Merit Review of Environmental Impact Statement for accredited assessment process – Atlas Campaspe Mineral Sands Project (EPBC 2012/6447)

Proposed Atlas Campaspe Mineral Sands Project, NSW
(SSD-5012 and EPBC 2012/6447)

Attachment A - Document Review Comments Sheet

Document Title: Environment Impact Statement, February 2013.

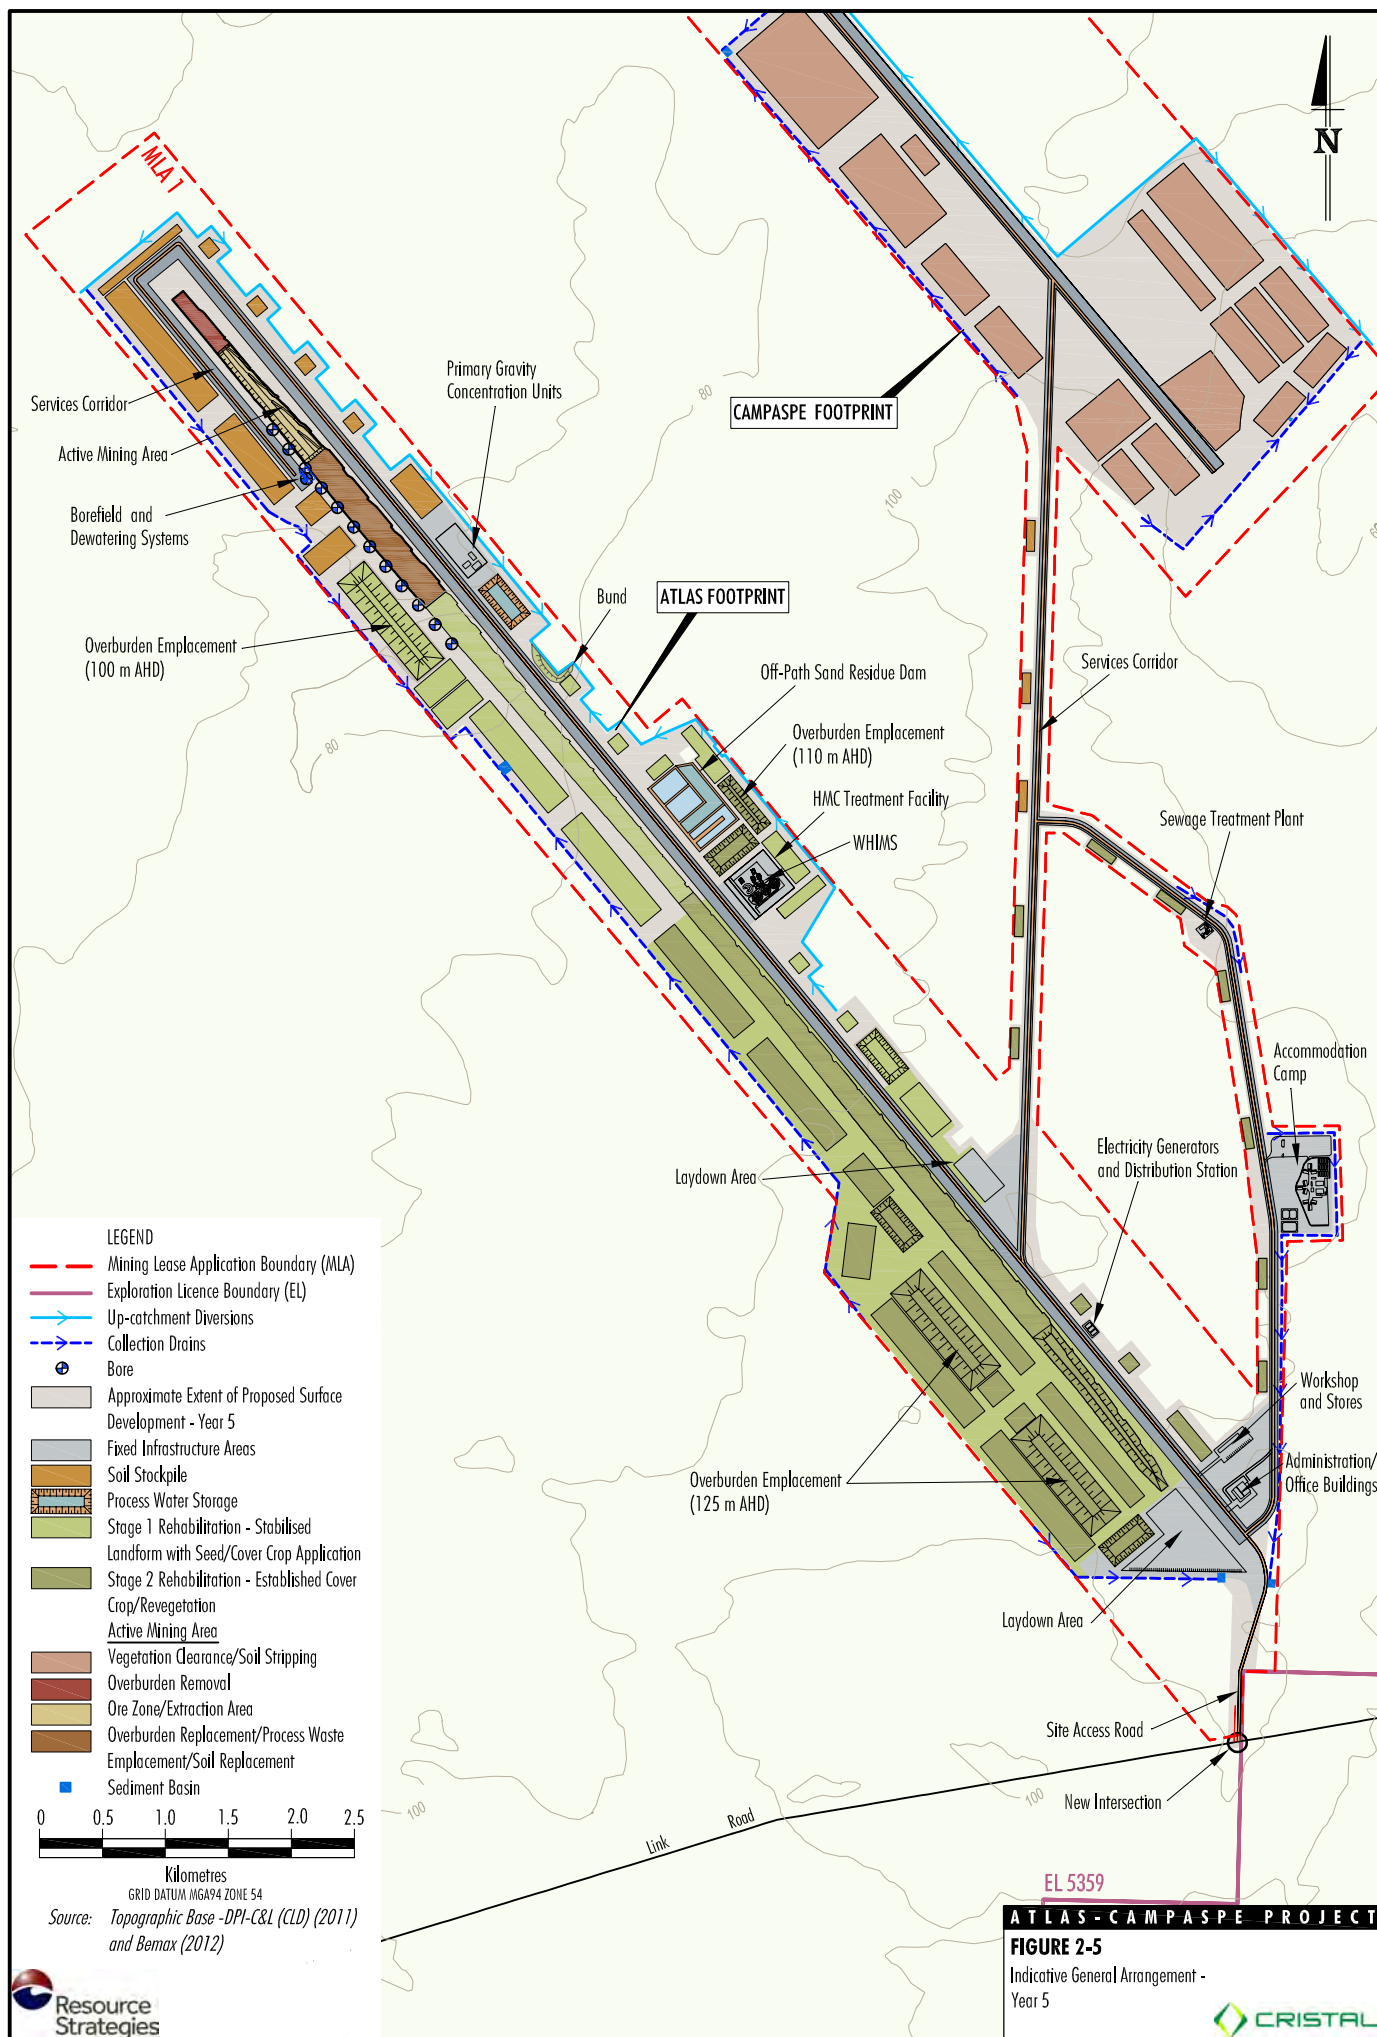
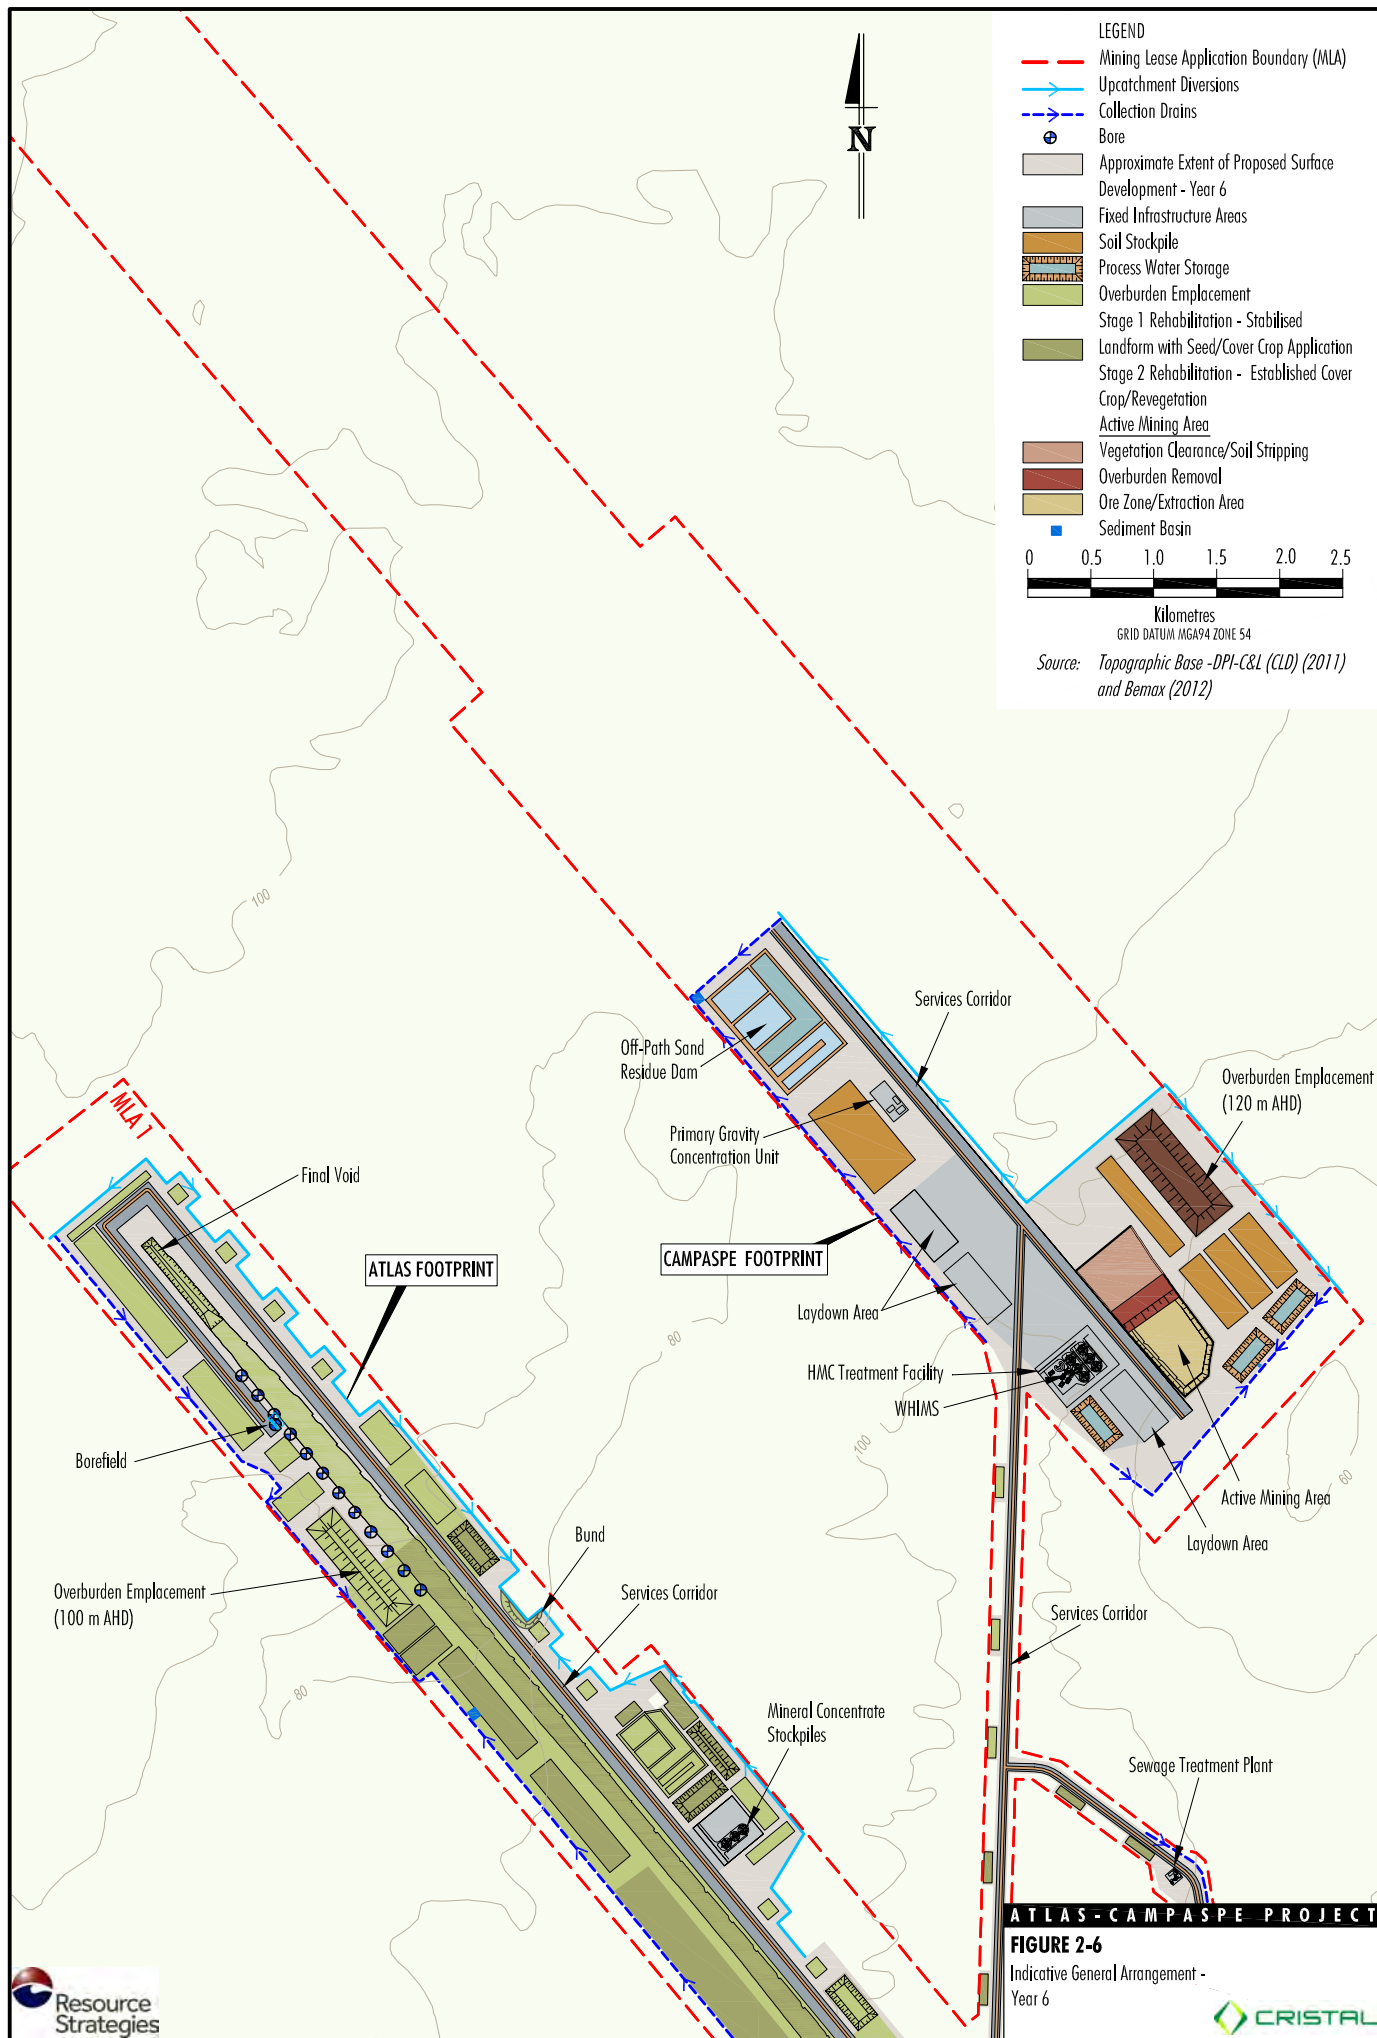
2. Description of the action	
(a) all components of the action.	<input type="checkbox"/> The area (in hectares) of <i>each</i> component of the action, including but not limited to, the proposed infrastructure at the mine site (identified in figures 2-4 and 2-5 of the EIS) is still outstanding. <input type="checkbox"/> Further detailed information about the proposed staging of rehabilitation works and how these relate to the timing and location of the advancing void is still required. Although the Department notes that these are depicted in the figures, we request further information about the timing of commencement of rehabilitation at particular areas in regards to the stage of extraction, and the progression of rehabilitation works in relation to the progression of the mine void.
